BE/87/20/L

107/109 North Bersted Street Bersted PO22 9AF

Listed building consent for a single storey rear extension

sheet 1 a of 2

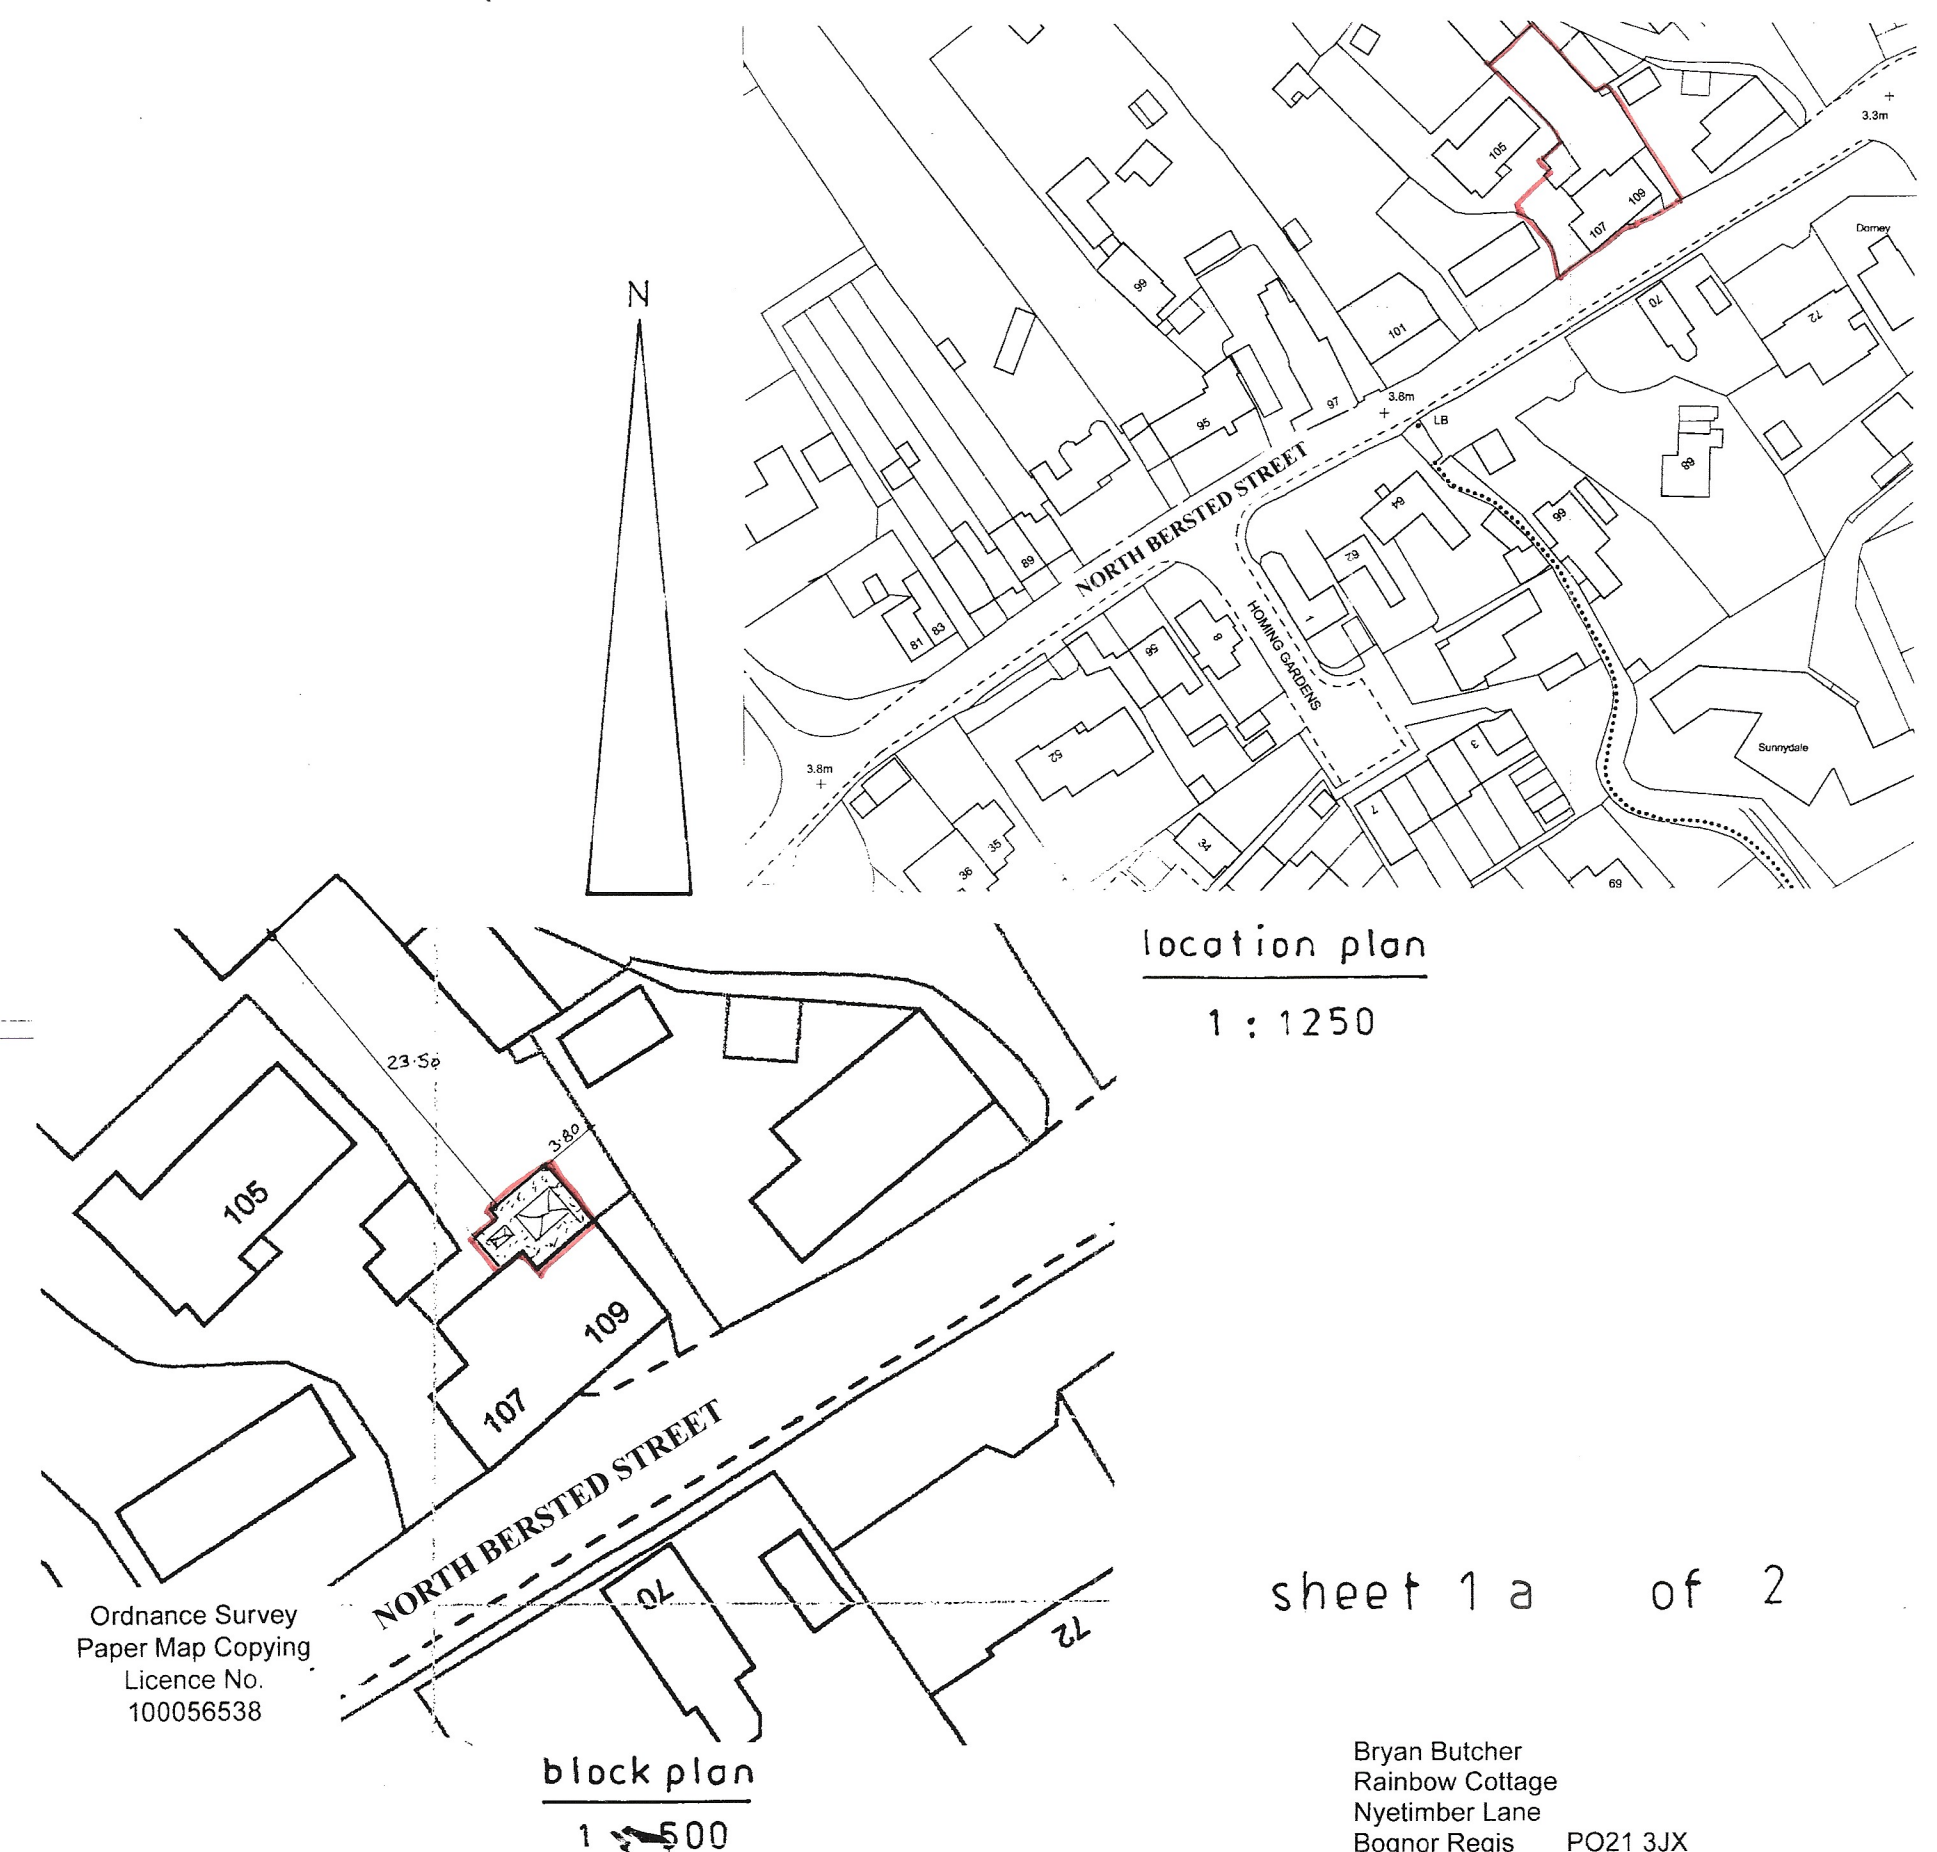
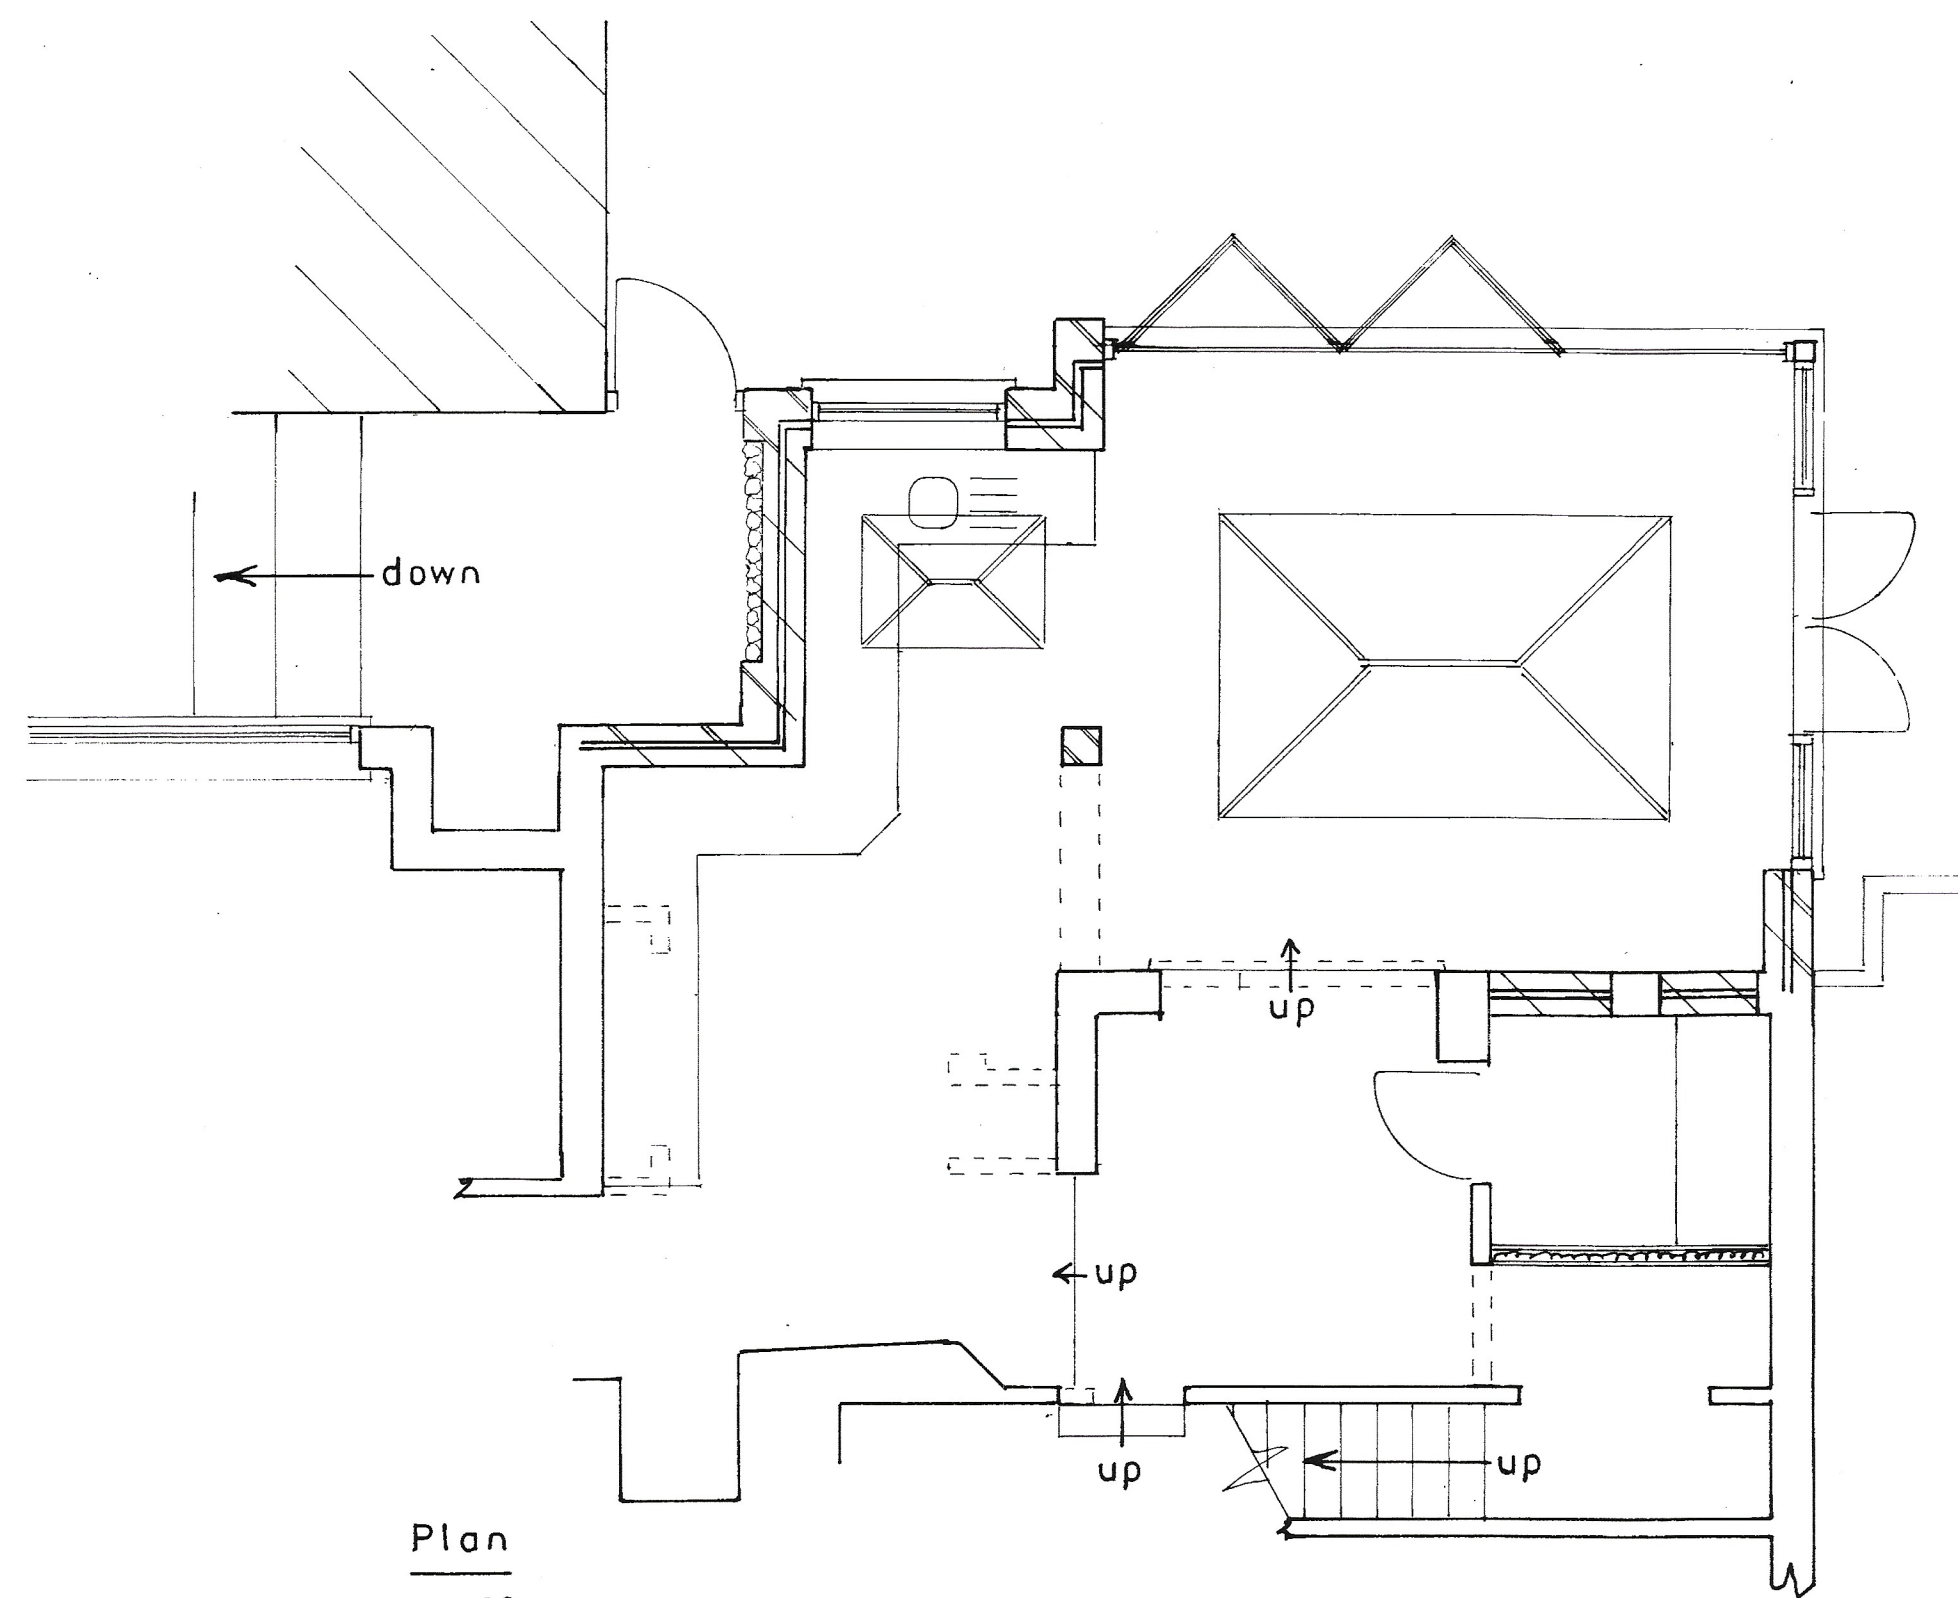
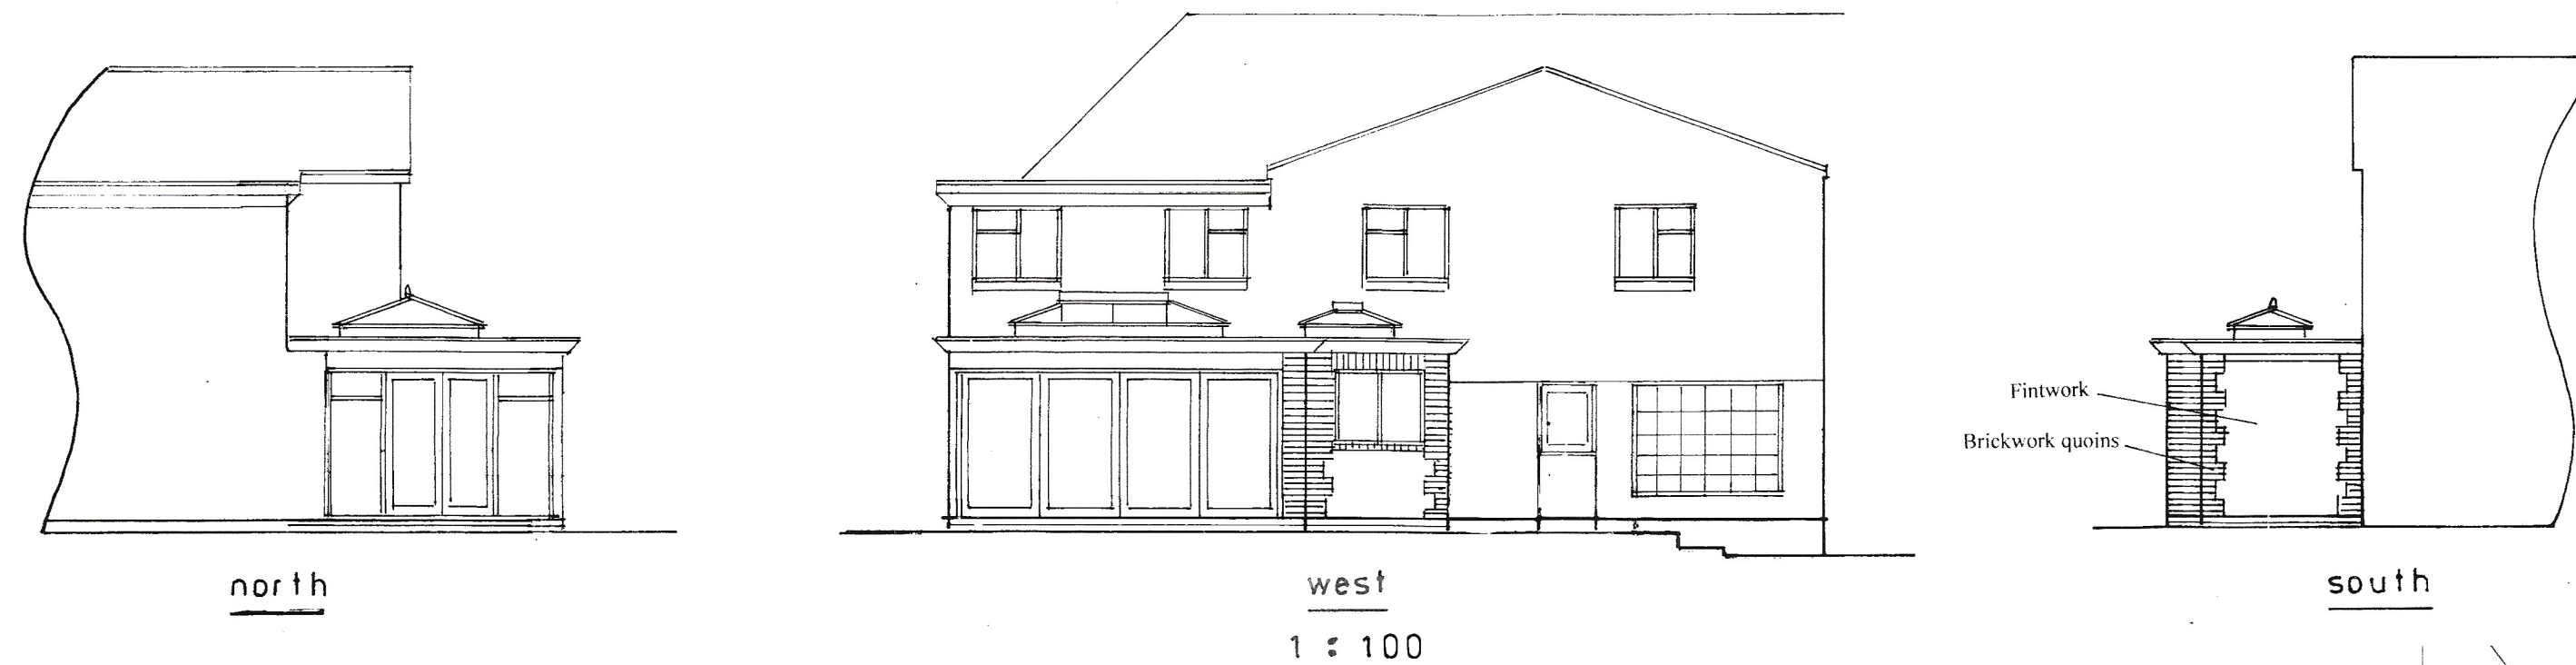
The proposal is to provide a further extension to an existing one. This extension is single storey and will accommodate a kitchen with doors looking out on to the garden area. As the proposal is attached to an existing modern extension, and there is the opportunity to improve the rear elevation, it is considered that the proposal is acceptable. This is subject to the use of appropriate/traditional materials and joinery which are appropriate for the listed building – at present it is not clear what materials are proposed. Details of the materials and windows/doors should be provided to the council, by way of condition. These should be supplied at an appropriate scale and level of detail to assess their impact.

Subject to the concerns raised regarding the proposed windows/doors being resolved, the application is considered to not cause harm to the significance of the heritage assets. As a consequence, it should be determined in accordance with the relevant policies within the Development Plan, along with these comments.
